DEVELOPMENT REVIEW BOARD  
SUPPLEMENTAL SUBMITTAL

Re: Inspiration Subdivision (Project # PR-2018-001759, Application # SD-2018-00129, VA-2018-00234, VA-2019-00025, VA-2019-00026, VA-2016-00027) Comment Response Letter

Enclosed are the responses to the comments provided on April 24<sup>th</sup> hearing. Comments and responses are listed below by department.

SHEET 3 of 3

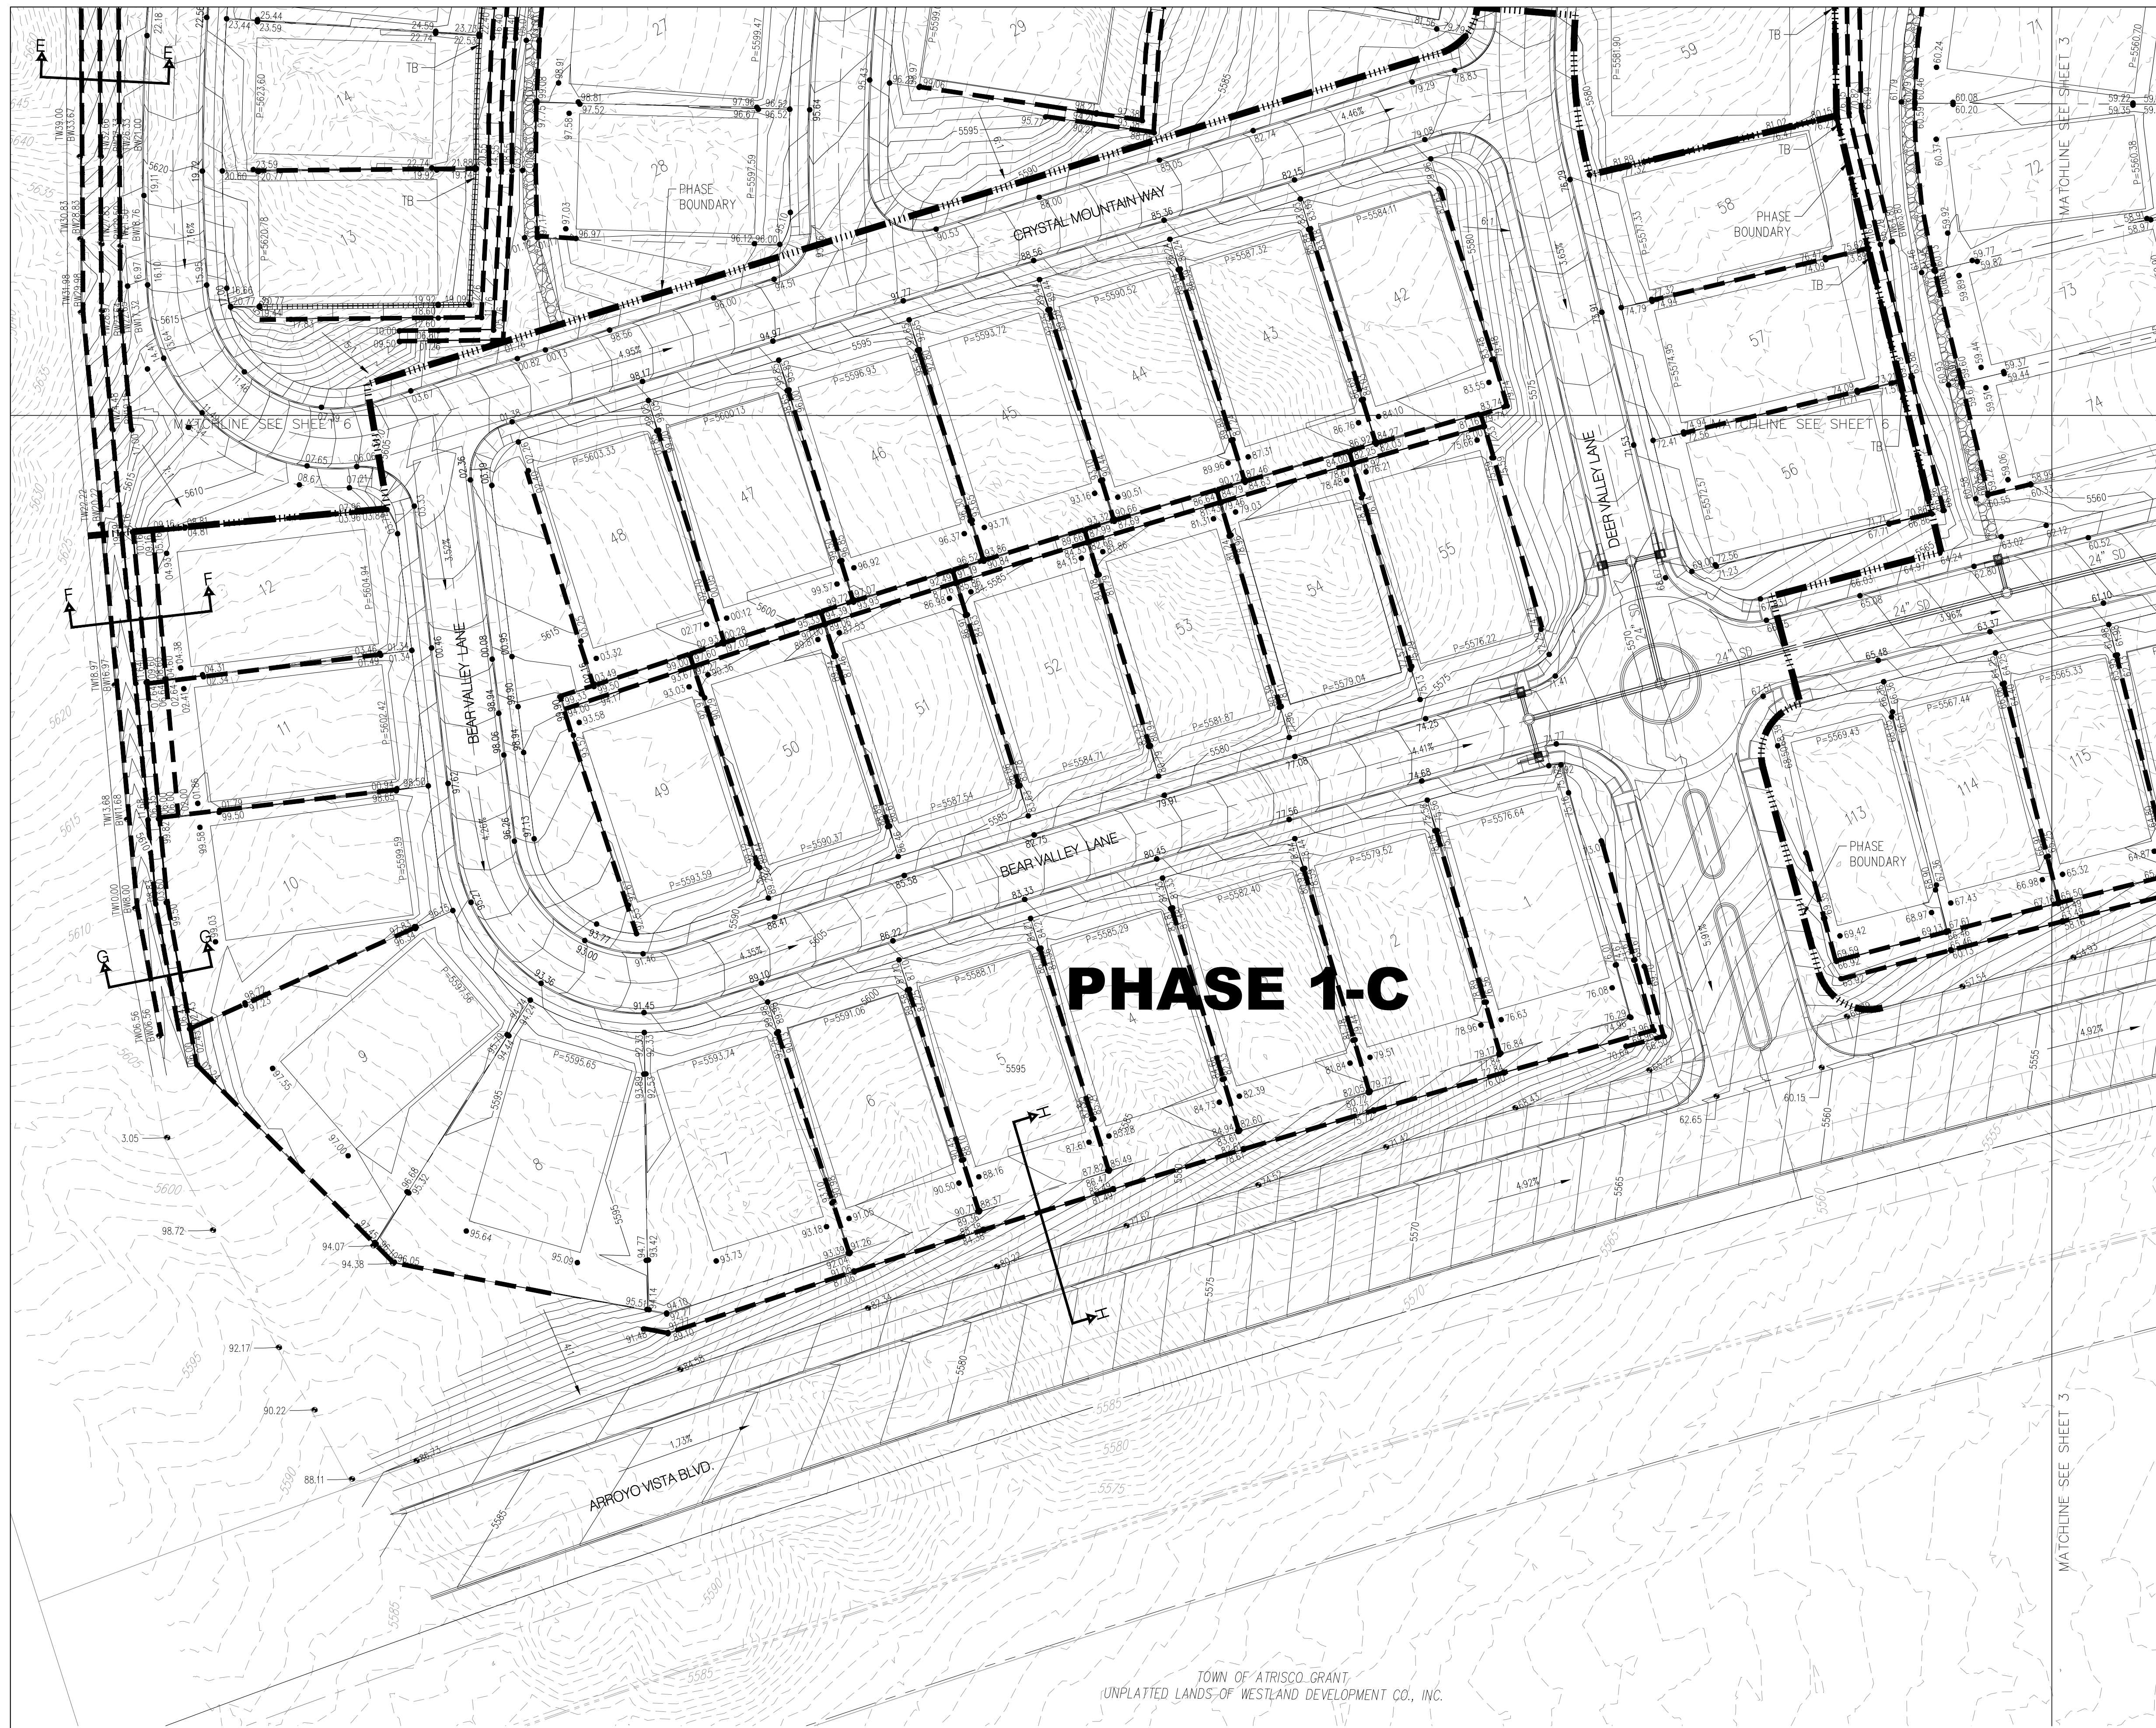
4. Remove the words "for Subdivision" in the notes concerning the site plan. It is an EPC site plan (there is no longer a difference in site plan types ie subdivision or building permit). Add the EPC application number.  
*Response: This has been corrected*

5. Note 4 the wording "granted" must be changed to "to be granted" by plat.  
*Response: This has been corrected*

6. Remove reference of the Sub Ordinance in note 6. Cite the actual wording.  
*Response: This has been corrected.*

3. Provide cross lot drainage easements on the HOA tracts naming maintenance responsibilities (HOA) and Beneficiaries (Parcel B, Westland North and Parcel A, Petroglyph)  
*Response: Cross-lot drainage easements added to the western boundary HOA tracts only which will accept from from Parcel B. We are not accepting any drainage from Parcel A the Petroglyph National Monument since this drainage away from our site. The note is correct on the plat*

4. "See Sheet 3 of 3 for 'drainage facilities maintenance note' for ownership and maintenance responsibility." This sentence needs to be added to the end of Easement Note 9 and 10. For Easement Note 10, delete everything after "H.O.A." and replace with the above sentence.  
*Response: Easement notes have been updated*
